**WELWYN HATFIELD BOROUGH COUNCIL – DEVELOPMENT MANAGEMENT**  
**DELEGATED REPORT**

<b>APPLICATION No:</b>	<b>S6/2012/1823/LUP</b>
<b>APPLICATION Site:</b>	<b>33 Kentish Lane, Brookmans Park</b>

The application seeks a certificate of lawfulness for a proposed two storey rear extension, extension of existing garage and conversion to habitable accommodation, loft conversion to include one rear dormer window, replacement canopy porch, enlargement to existing chimneys and new bin store.

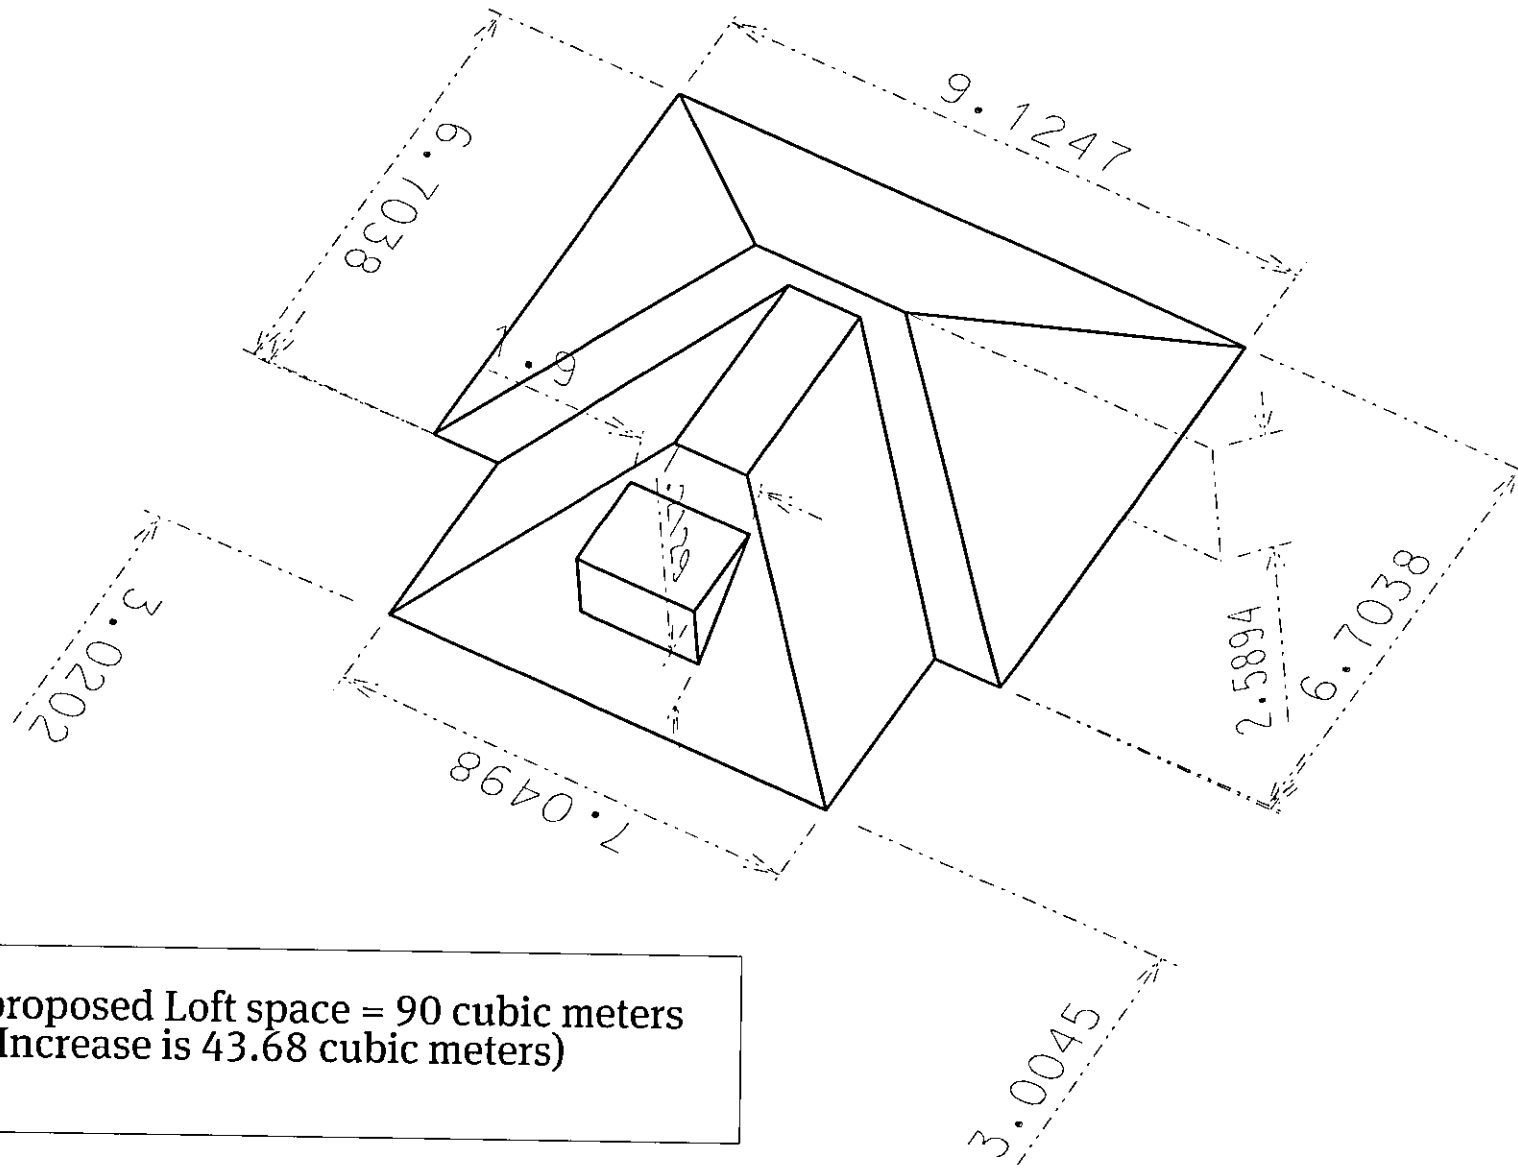
(c) the cubic content of the resulting roof space would exceed the cubic content of the original roof space by more than:-

*Proposed rear dormer windows: (w) 2.1m x (h) 1.2m x (d) 1.4m /2 = 1.8m<sup>3</sup>*

*Proposed roofspace above two storey rear extension = 47.1m<sup>3</sup>*

*Total additional roofspace: **48.9m<sup>3</sup>**.*

*The proposal therefore fails to comply with part (c) (ii)*

Drawing title
Proposed Section AA

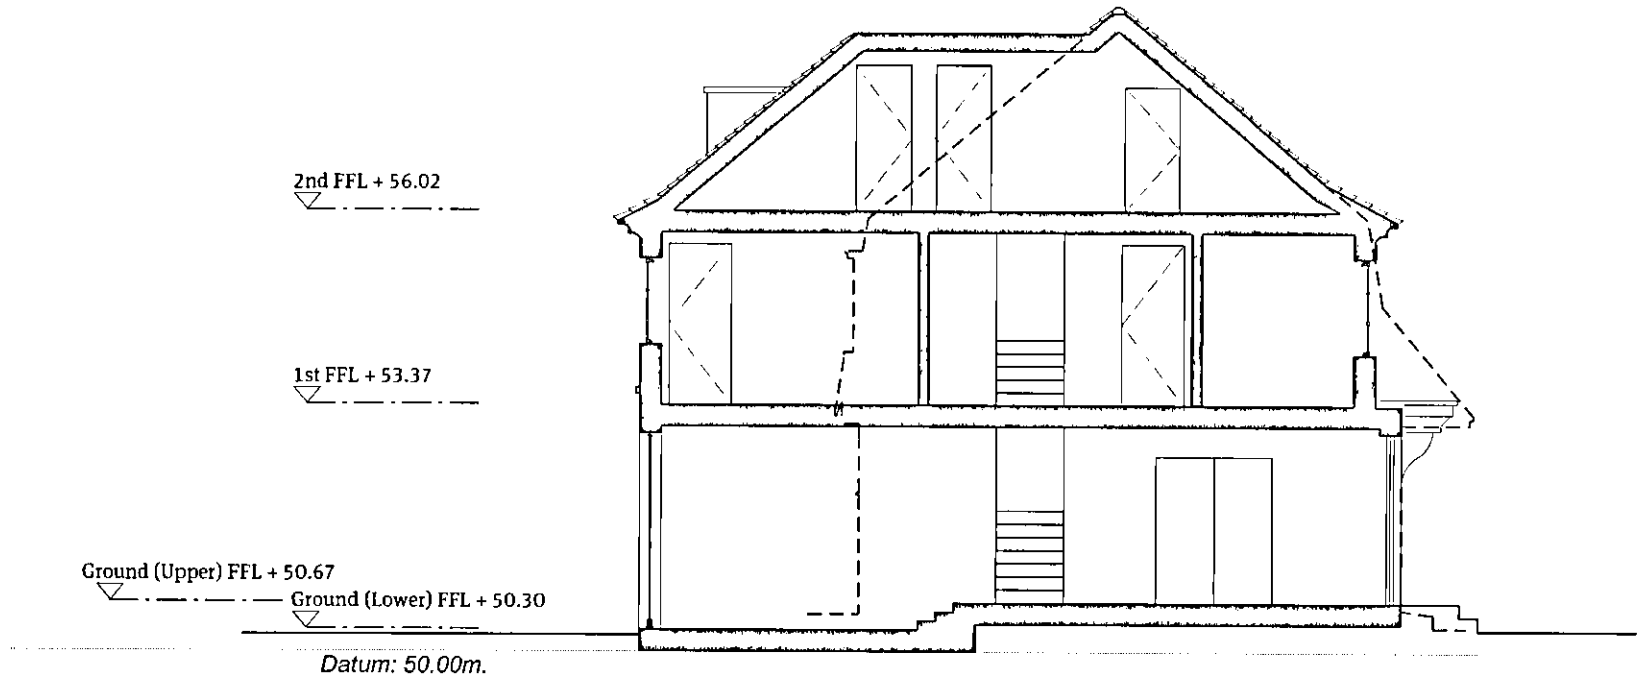
*The proposed two storey rear extension measures no more than 3m in depth and would not be within 7m of the boundary from the rear wall.*

*The proposal has more than one storey and the pitch of the roof will match that of the existing roof of the dwellinghouse*
